Phone: 0300 123 6780  
Email: [developeras@lancashire.gov.uk](mailto:developeras@lancashire.gov.uk)  
Your ref: 3/2025/0141  
Our ref: 3/2025/0141/HDC/KW  
Date: 01 December 2025

**Location:** Bolton Fold Farm Alston Lane Longridge PR3 3BN  
**Proposal:** Regularisation of erection of three commercial buildings (10 commercial units Use Class B2, B8 and sui generis) and associated works.  
**Grid Ref:** 360295 435306

Job/Scheme Number	Drawing Number
0616/93	Drawing No 07D
Scale	Date
1 / 250	May 2
Drawn	Checked
a.t.l-h.

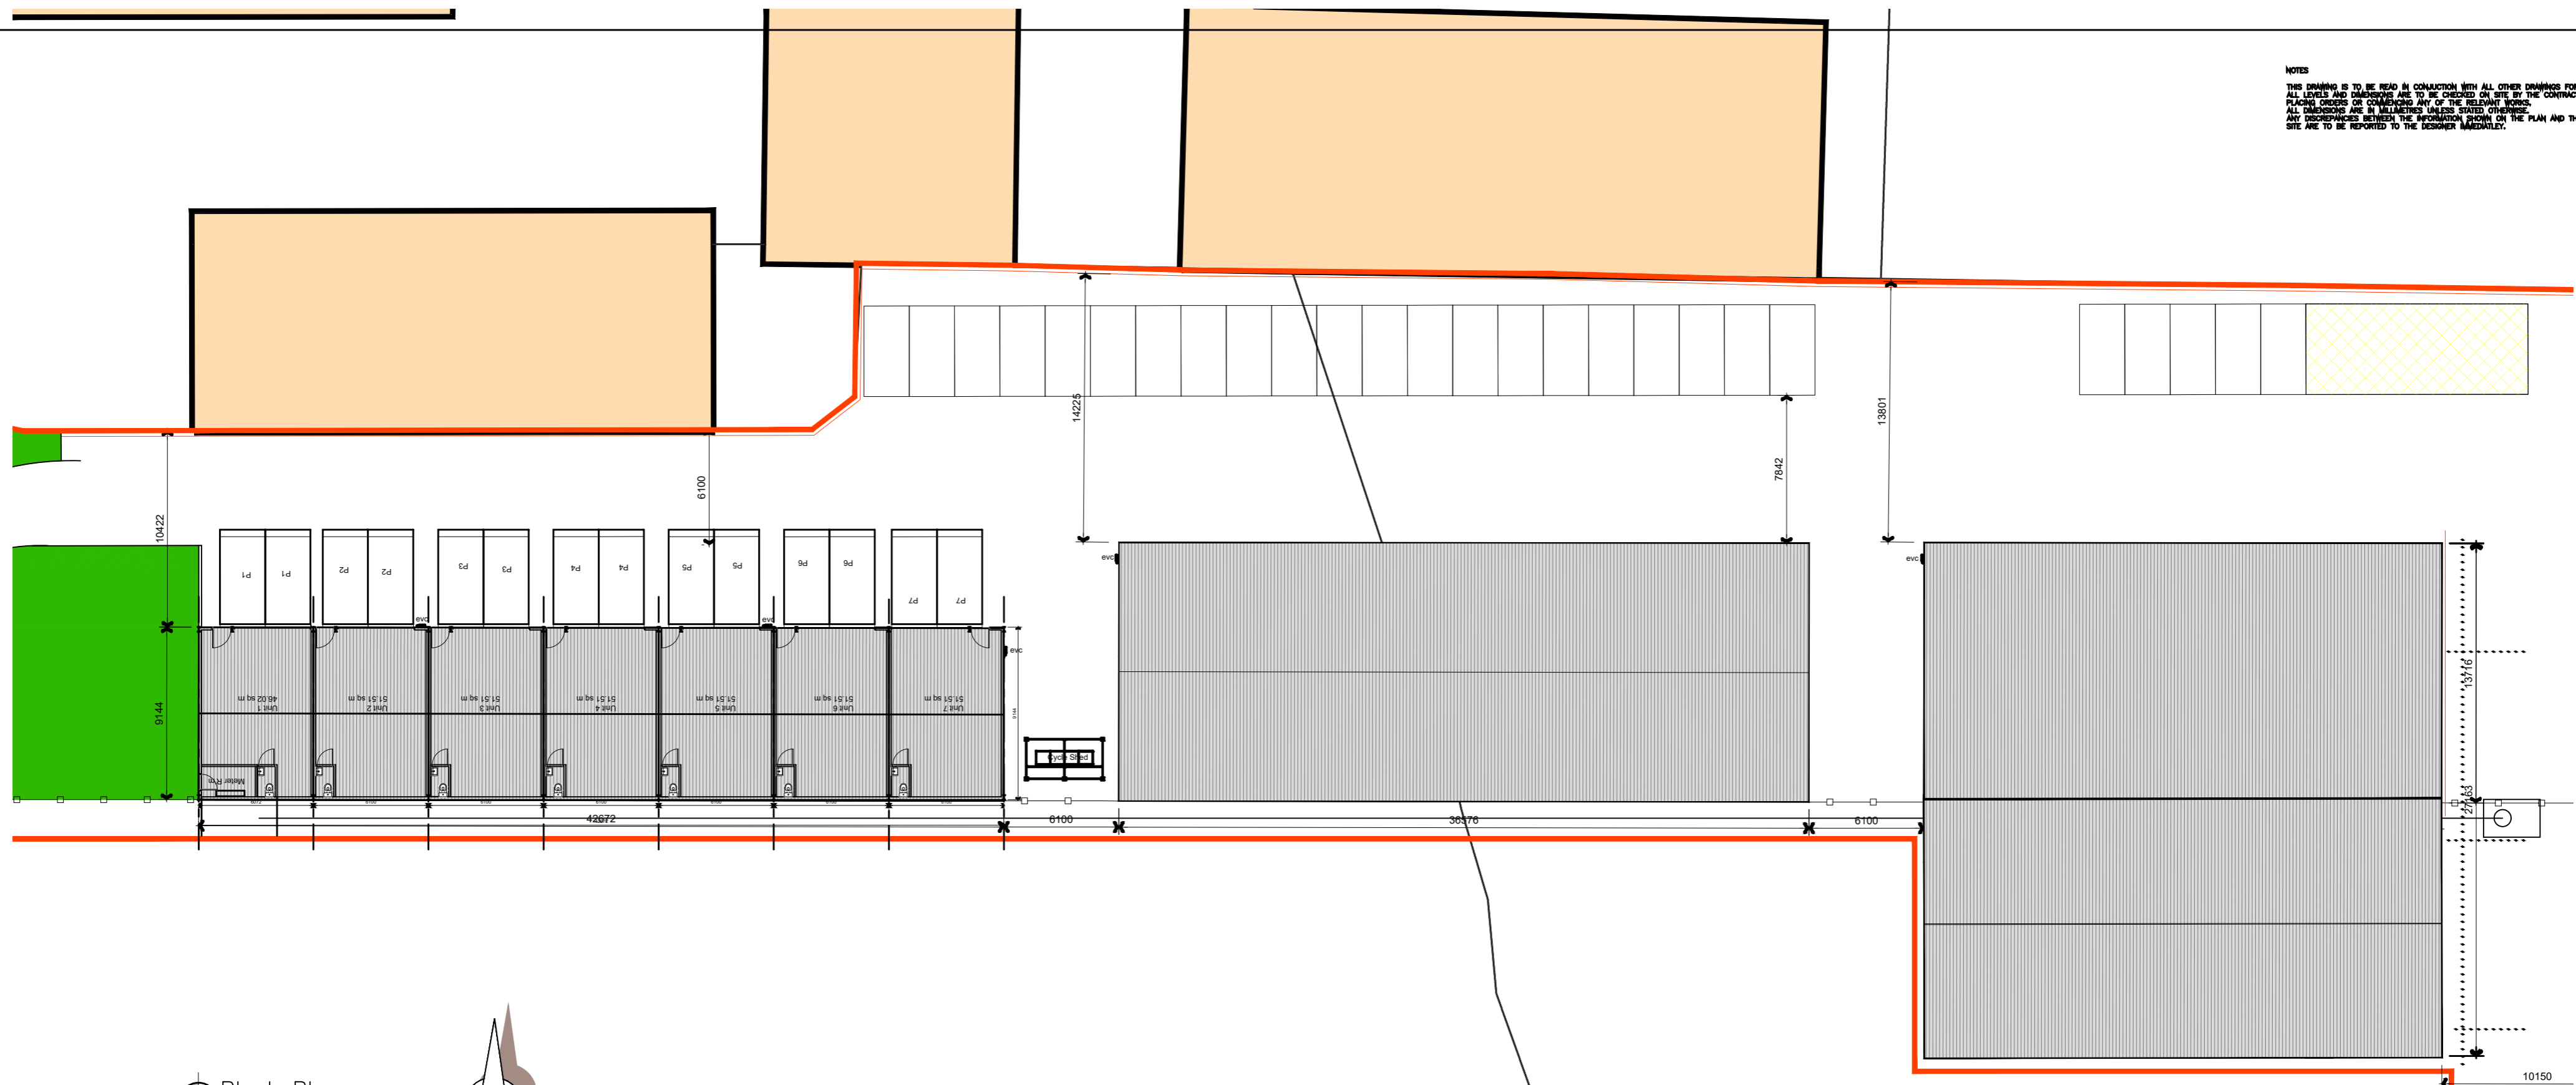
The agent has provided further details on the use of each commercial unit within the site. Units 1-7 measure a total of 387m<sup>2</sup>, requiring a ratio of 1 parking space per 45m<sup>2</sup> which is a total of 9 spaces. Units 8-9 measure a total of 505m<sup>2</sup>, requiring a ratio of 1 parking space per 45m<sup>2</sup>, which is a total of 12 spaces. Resulting in a total of 21 spaces.

Unit 10 measures 745m<sup>2</sup>, requiring a ratio of 1 parking space per 200m<sup>2</sup>, which is a total of 4 spaces.

The LHA has reviewed the updated site plan, drawing number 07 D, which shows a total of 26 parking spaces situated along the north edge of the site. As such, there is an appropriate and sufficient parking for the site.

The site also offers sustainable transport options to encourage and promote sustainable transport use. A dedicated cycle store has been provided within the site next to unit 7. Additionally, charging points for electric vehicles are included in the development to promote sustainable modes of transport. The DfT guidance regarding Electric Vehicle Charging in Residential and Non-residential buildings states that charge points must have a minimum power rating output of 7kW and be fitted with a universal socket that can charge all types of electric vehicles.

**Reason:** To mitigate the impact of the development traffic on the highway network.
2. The development hereby permitted shall not be occupied or brought into use until the car parking and turning areas shown on the approved plan(s) have been provided in full and are available for use. The car parking and turning areas shall thereafter be kept available for the parking and manoeuvring of vehicles at all times.

**Reason:** To ensure the provision of adequate car parking on site and in the interests of highway safety.
3. Off-street parking shall include the provision of an electrical supply suitable for charging an electric motor vehicle.

**Reason:** To support sustainable transport objectives and to contribute to a reduction in harmful vehicle emissions
4. Prior to first occupation cycle storage provisions shall be submitted to the Local Planning Authority, in consultation with the Local Highway Authority. These cycle facilities shall thereafter be kept free of obstruction and available for the parking of bicycles only at all times.

Job/Scheme Number	Drawing Number
0616/93	Drawing No 07C
Scale	Date
1 / 250	May 2
Drawn	Checked
a.t.l-h.

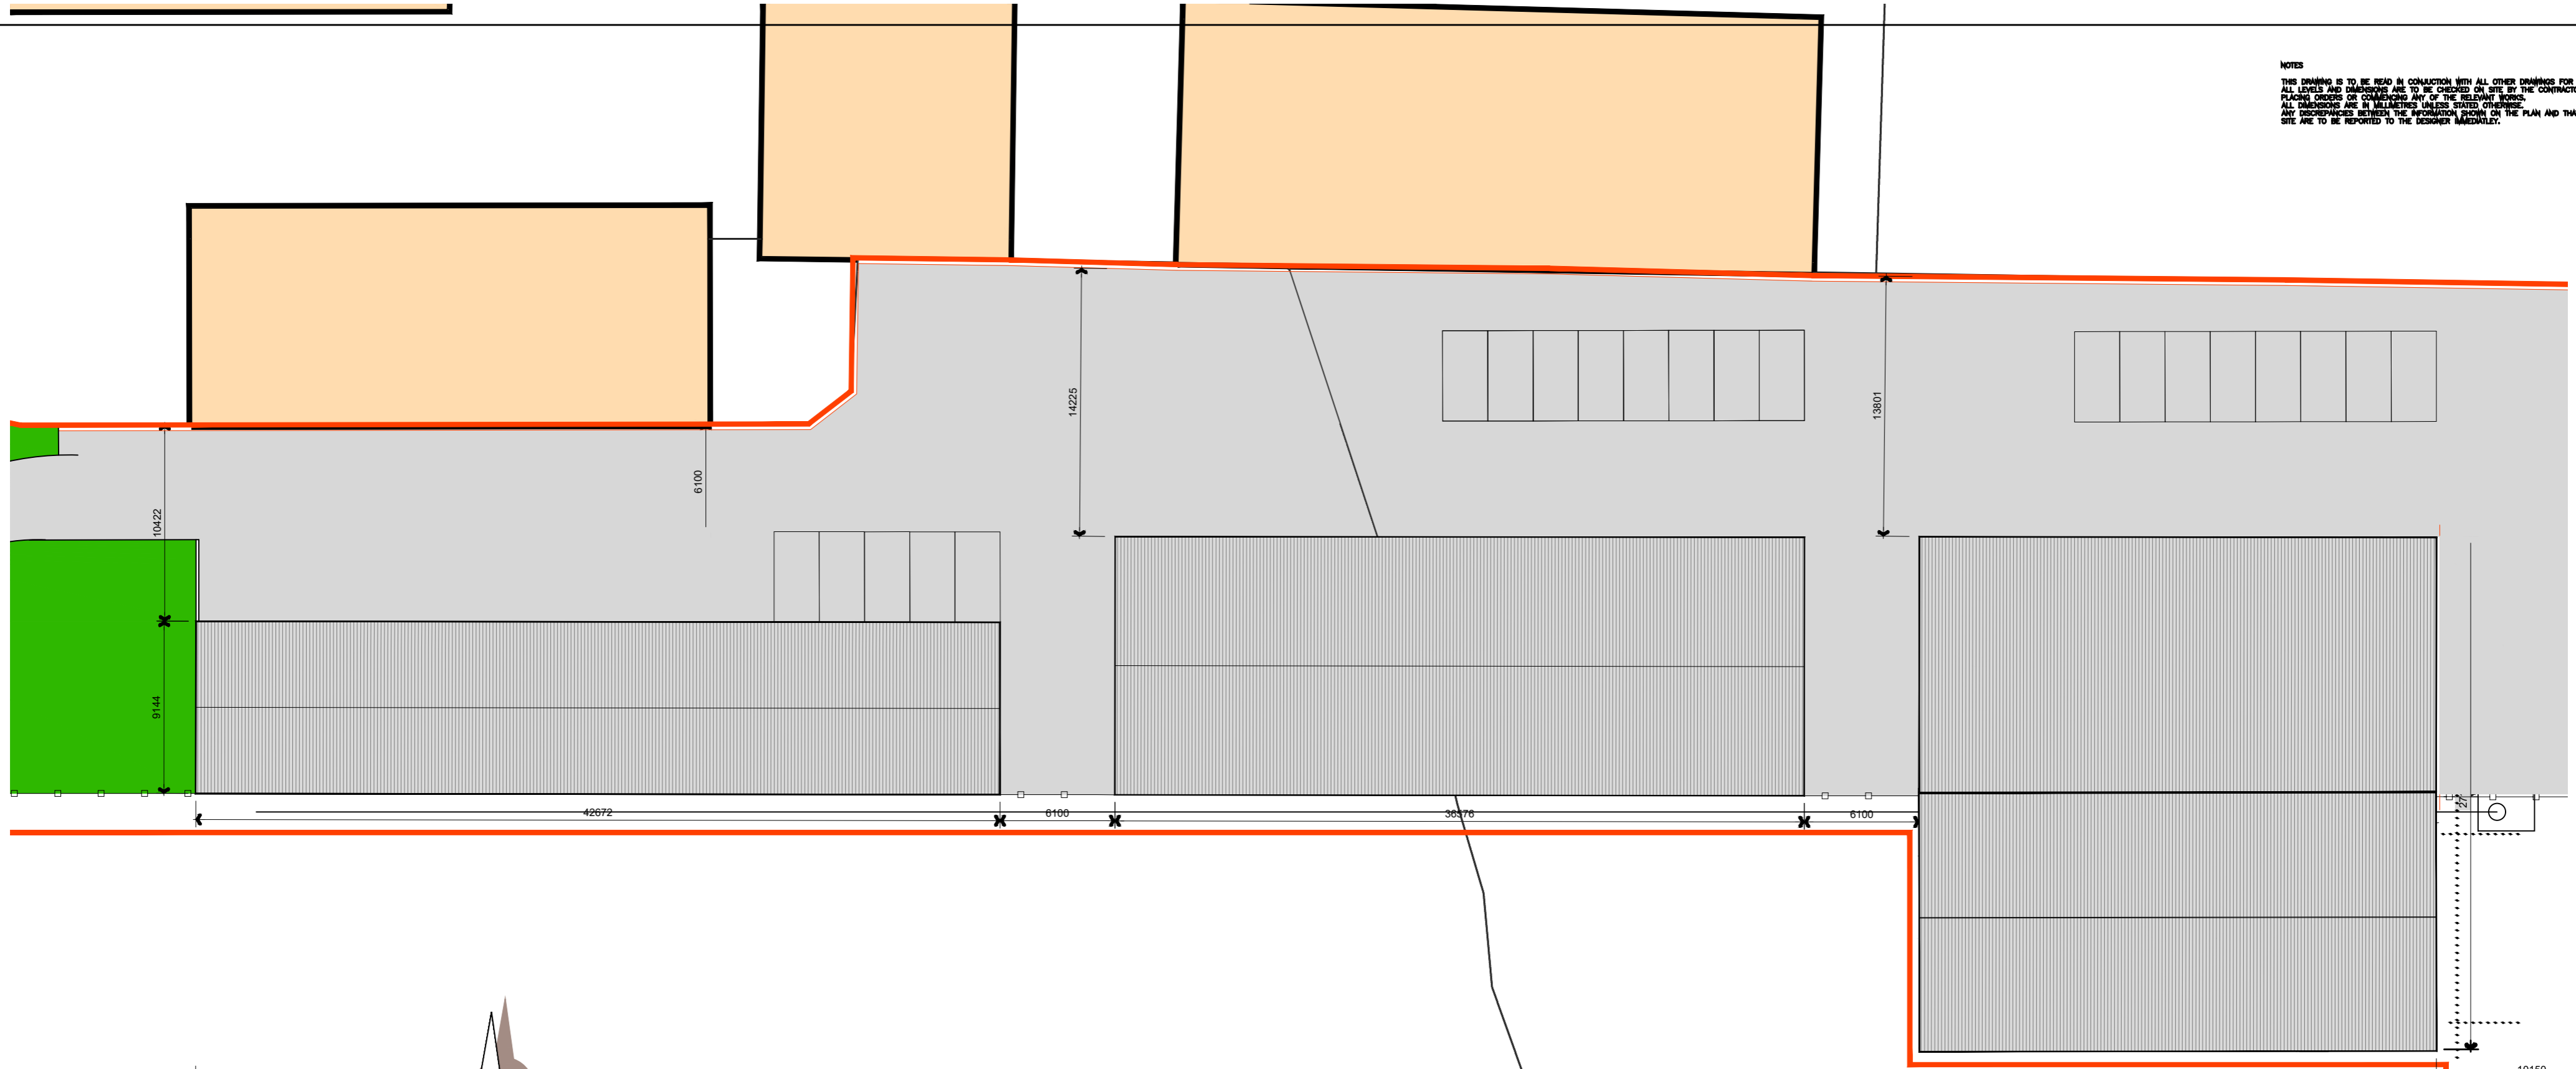
The LHA has reviewed the proposed location plan, drawing number 00C and noted that the proposal will utilise an existing access from Alston Lane, which is an unclassified road subject to a 60mph speed limit. The access was also considered as part of a previous application, 3/2024/0618 for an industrial storage unit. The access is an appropriate width and depth to serve the proposed commercial units. Whilst the internal access track leading from the access to the units is single track width, visibility over the internal track from within the access is good and there is adequate space to give way.

Proposed Site Layout
 Swept Path Analysis
 10m Rigid

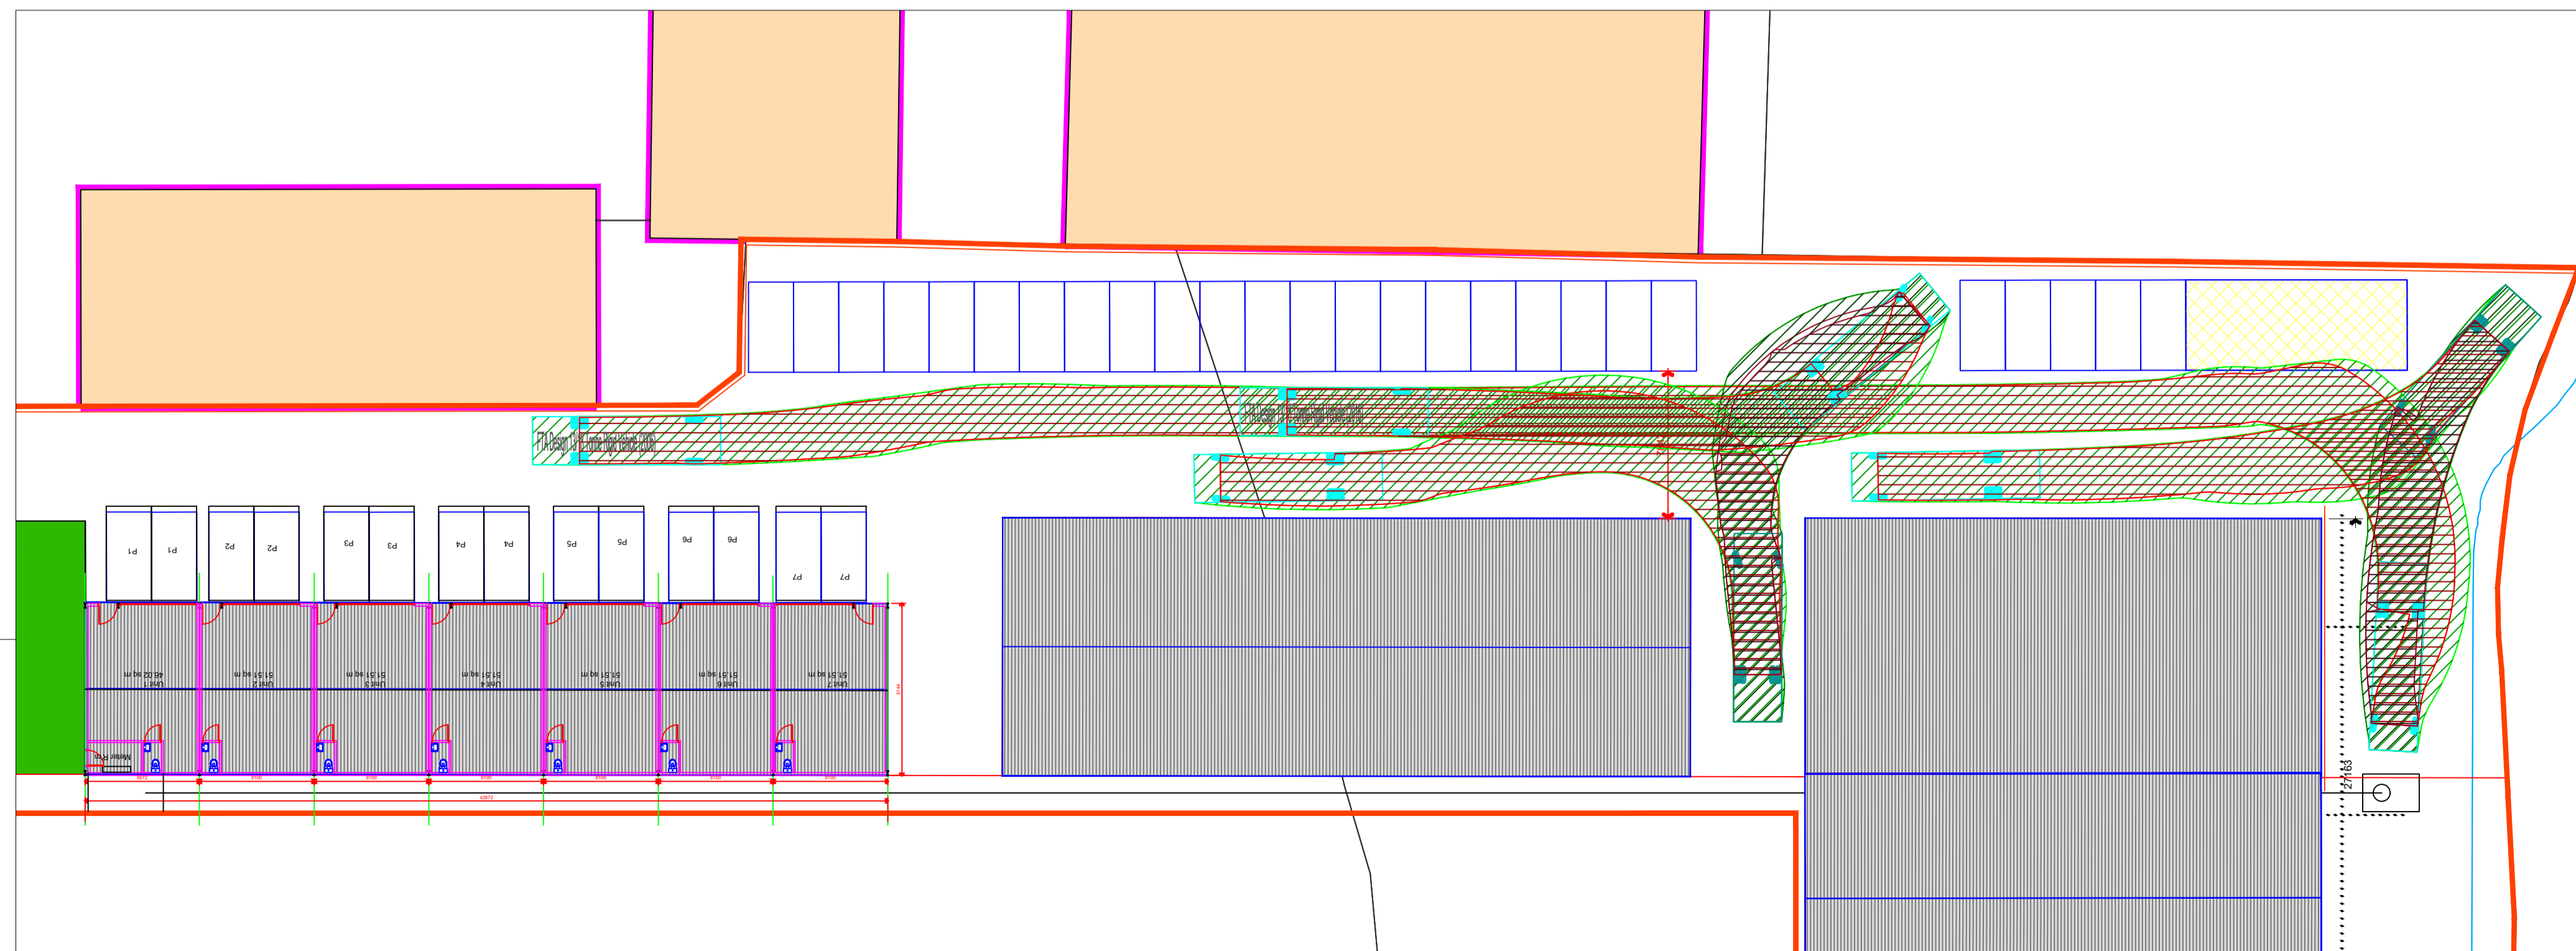
The LHA have reviewed the internal layout. The applicant has provided further information regarding the vehicles which are expected to travel to and from site as well as detailed tracking shown on the plan titled Proposed Site Layout Swept Path Analysis 10m Rigid, drawing DTP/3707323/ATR001 Rev C, which shows a 10m Rigid Vehicle turning within the site which shows ingress and egress is possible in forward gear. The amendment addresses the previous concerns regarding conflict with vehicle parking areas. The proposal will ensure that the turning area does not conflict with vehicle parking within the site and that this area remains clear for servicing.
